29 November 2012

**National Biodiesel Limited Soybean Crushing Facility and Biodiesel Refinery,
Port Kembla
Comments in relation to Proposed Modification (08_0083 MOD 1)**

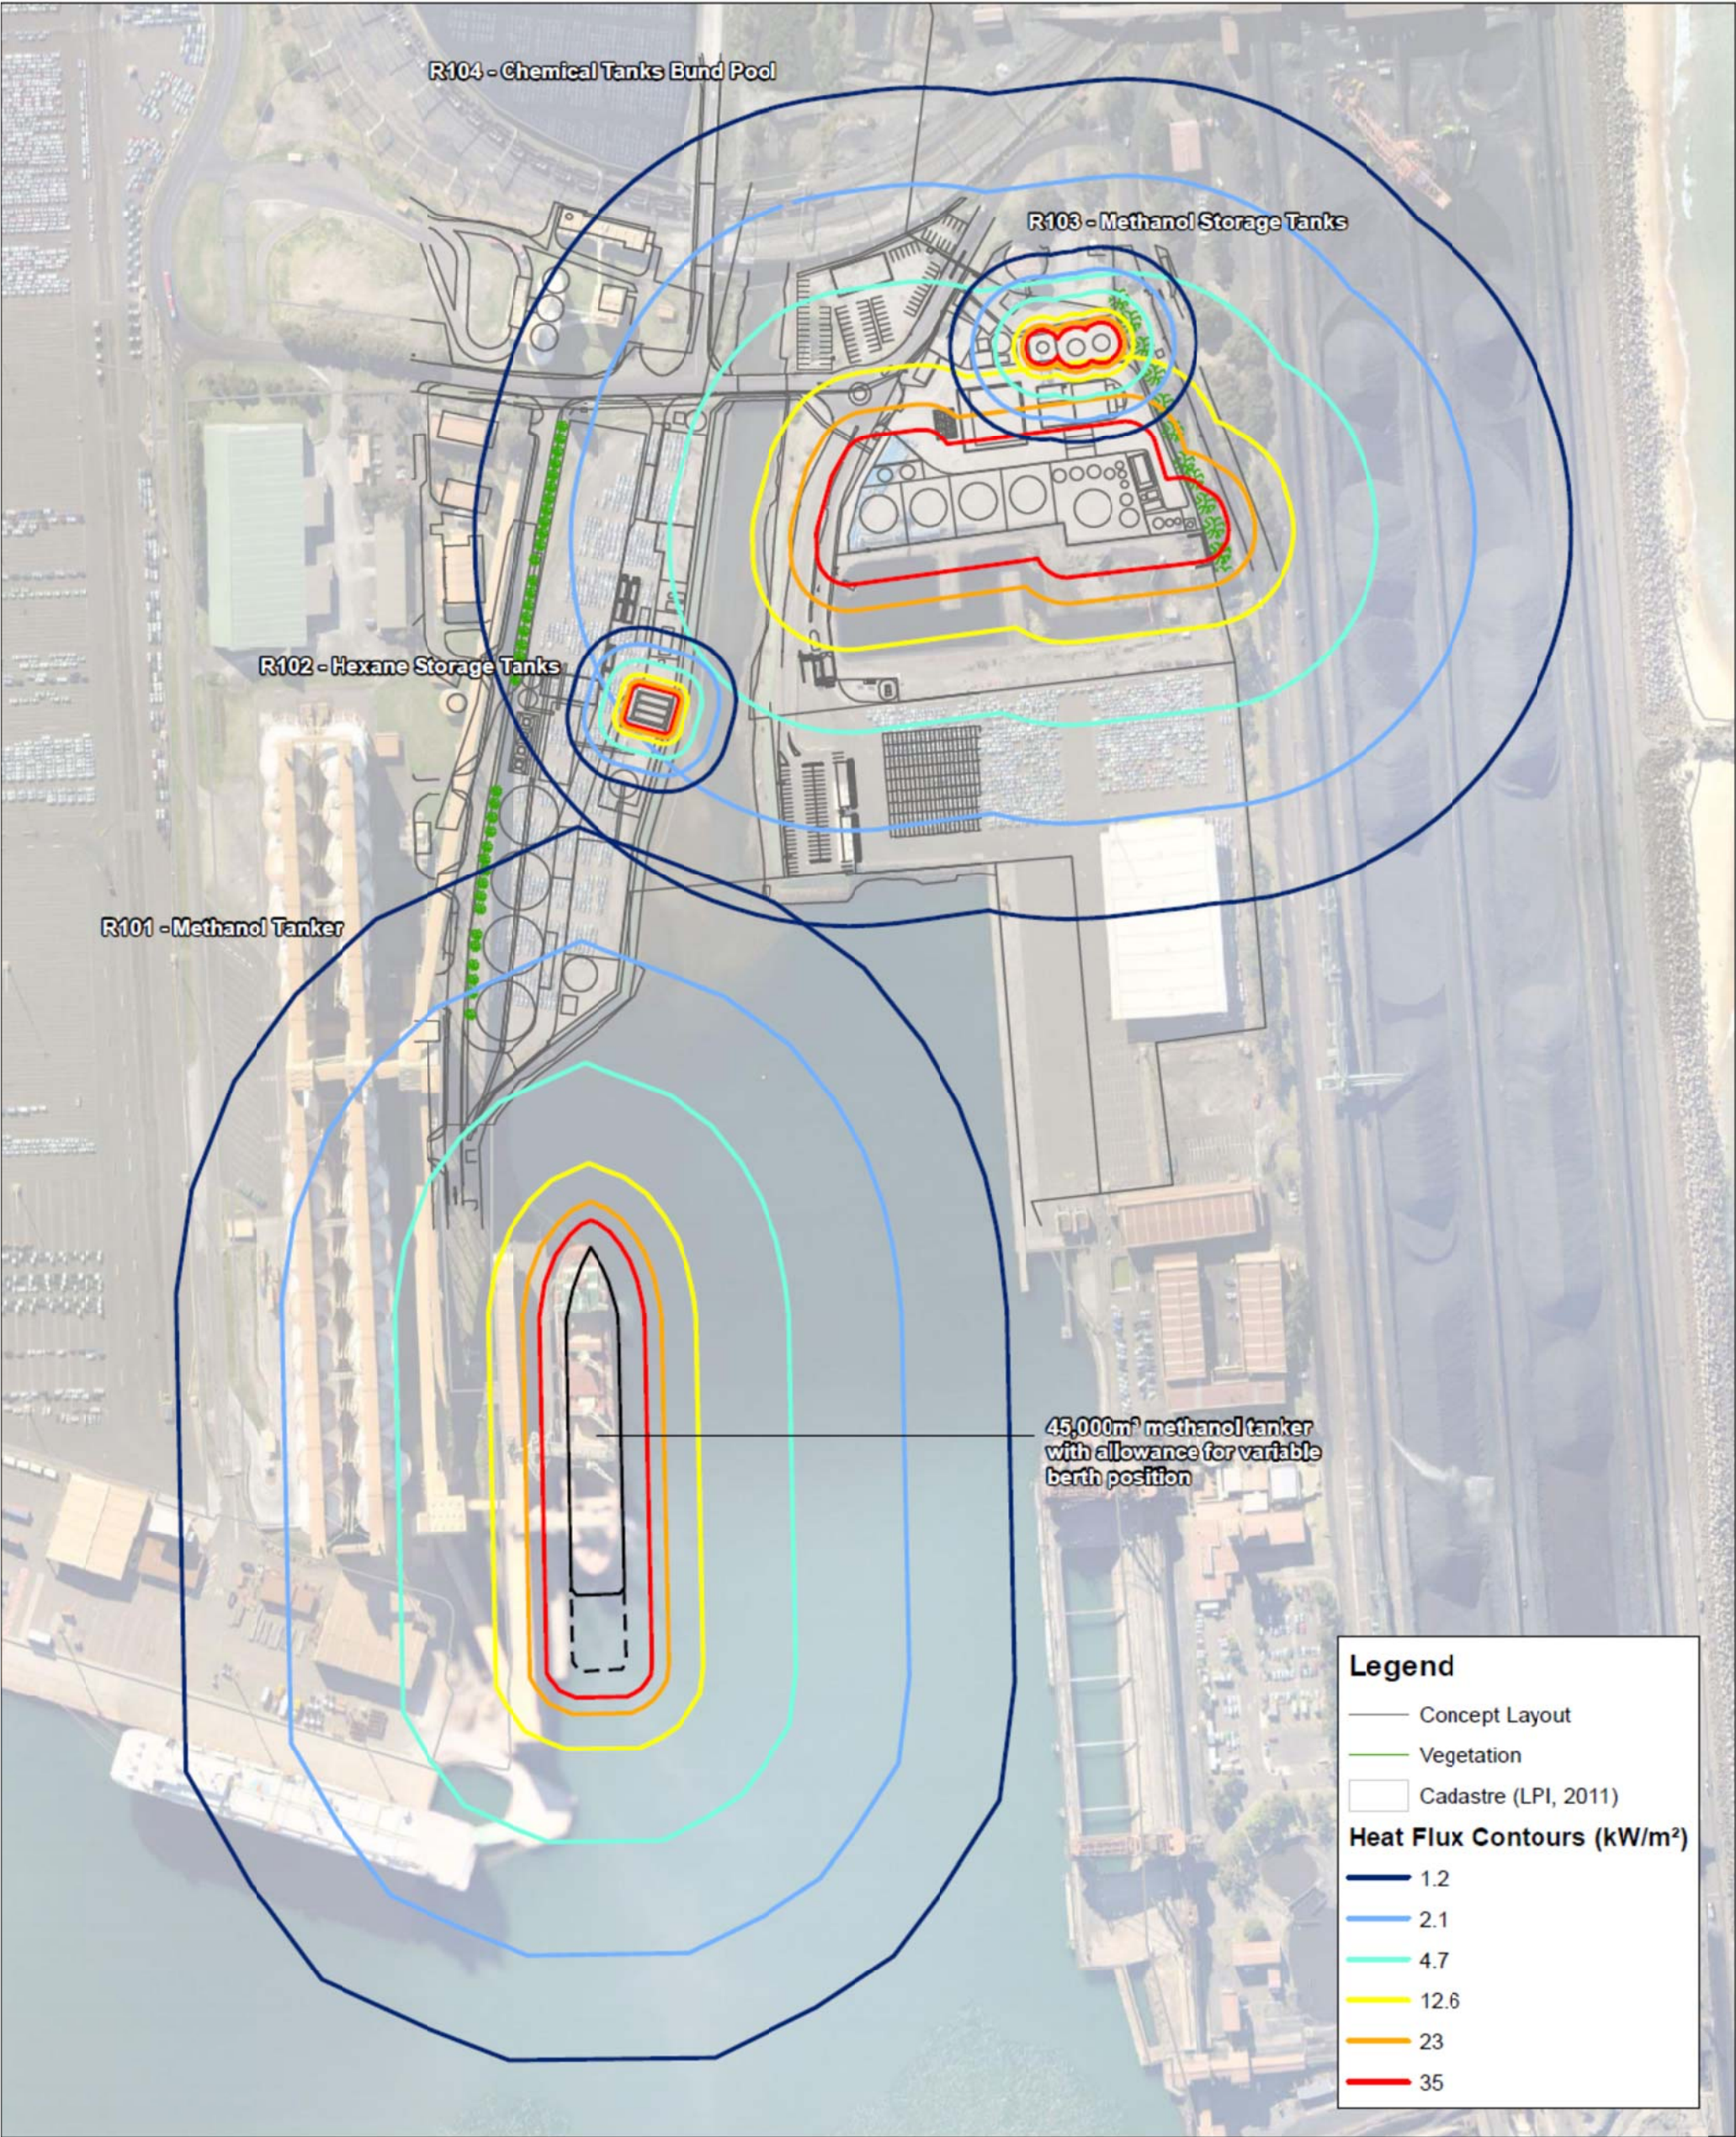
- The heat flux contours shown in Figure 5 around the methanol tanker at Berth 104 are noted. The safety of personnel and unimpeded use of

neighbouring sites, particularly Port Kembla Grain Terminal to the west and AAT's Berth 105 - 107 Terminal to the southwest, must be ensured.

- The proponent should continue to consult with PKPC, GrainCorp and AAT regarding the design and operation of the bulk unloading facilities, including associated fire fighting and spill control measures, hazards and risks.
- The Proponent should obtain its own environment protection licence for shipping in bulk at the Berth 104 facility prior to commencement of Stage 1 operations.
